CITY OF ALBUQUERQUE

October 16, 2018

RE: **13424 Cedarbrook Ave NE**
Grading and Drainage Plan
Engineer's Stamp Date: 9/24/18
Drainage File: F23D013

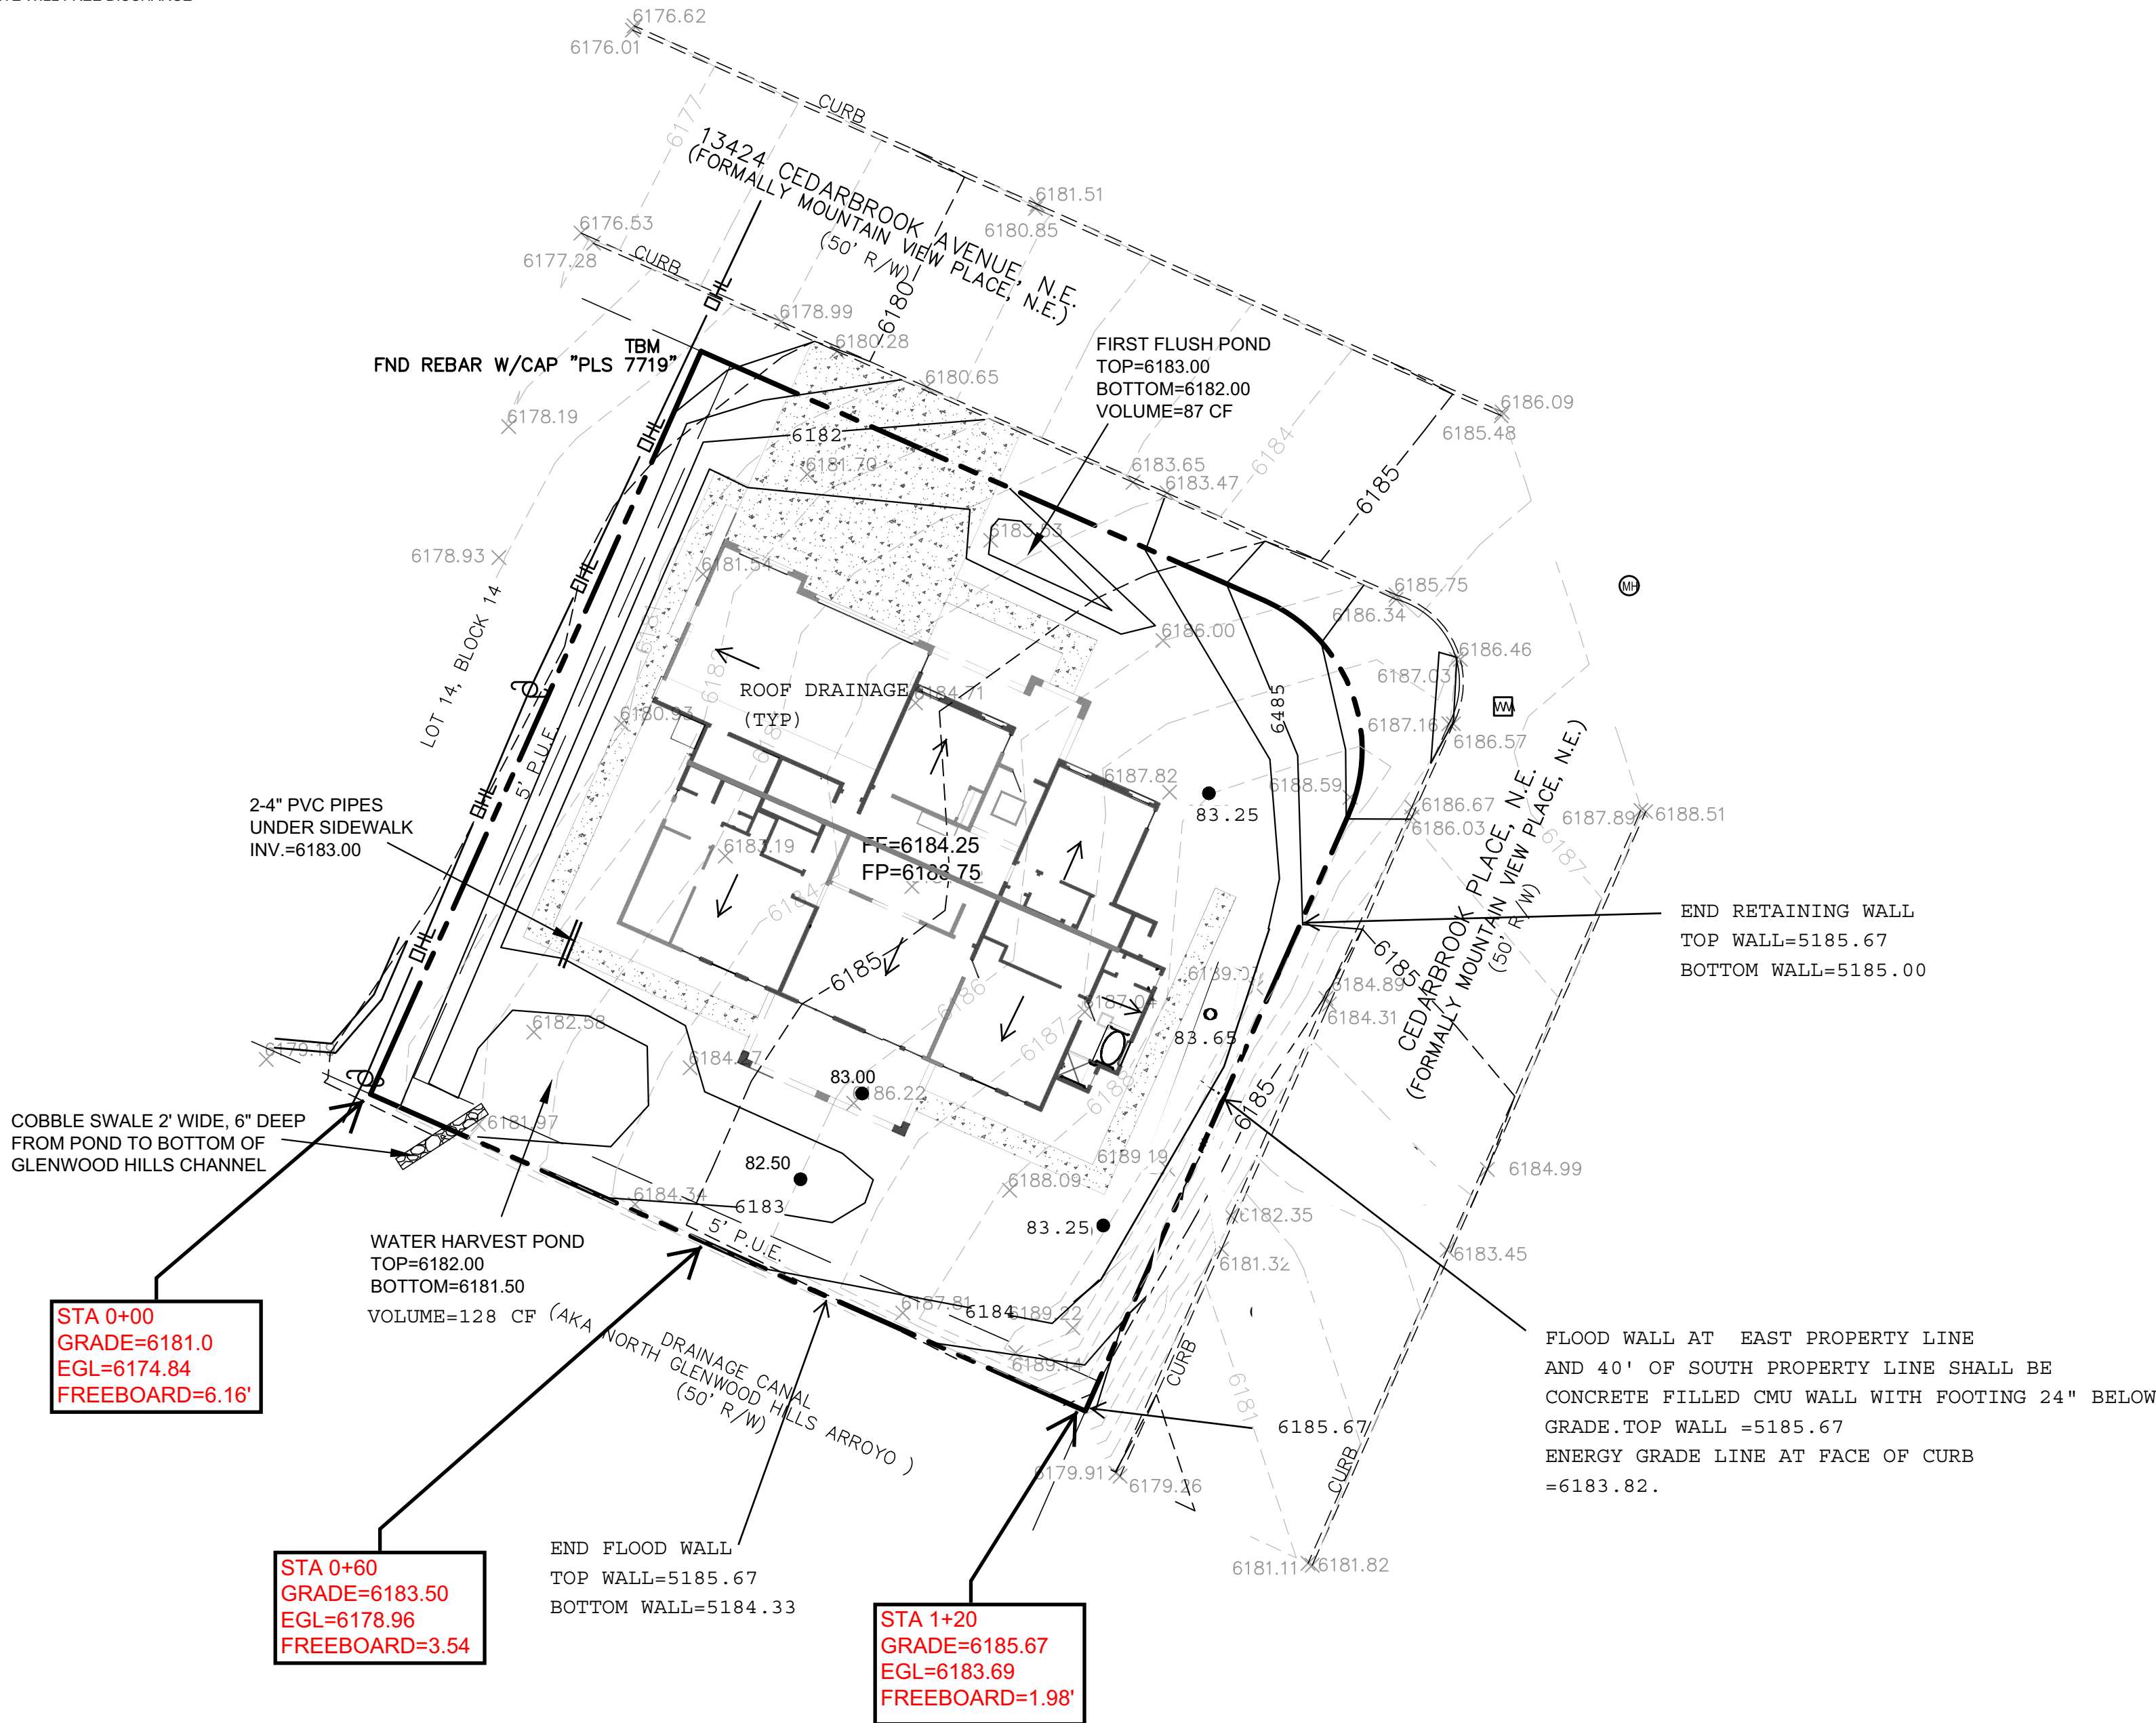
1. Please update the stamp date.
2. The 40-acres or less method is not reasonable for this watershed; provide subbasins and an AHYMO model or HEC-HMS model to determine Q_{100} .
3. Provide a profile of the arroyo, beginning at the upstream edge of Cedarbrook Place crossing. Include: bottom of arroyo, normal depth, critical depth, top of existing and proposed banks, the proposed building pad and freeboard.
4. Provide freeboard per DPM Ch22.C.4. Freeboard will need to be measured from the water surface on the road crossing to the top of the pad. If flows are calculated as supercritical; then the critical depth will need to be used as the controlling water surface.
5. Show the adjacent grades in N Glenwood Hills Arroyo; ensure that your grading ties-in at the ROW line.
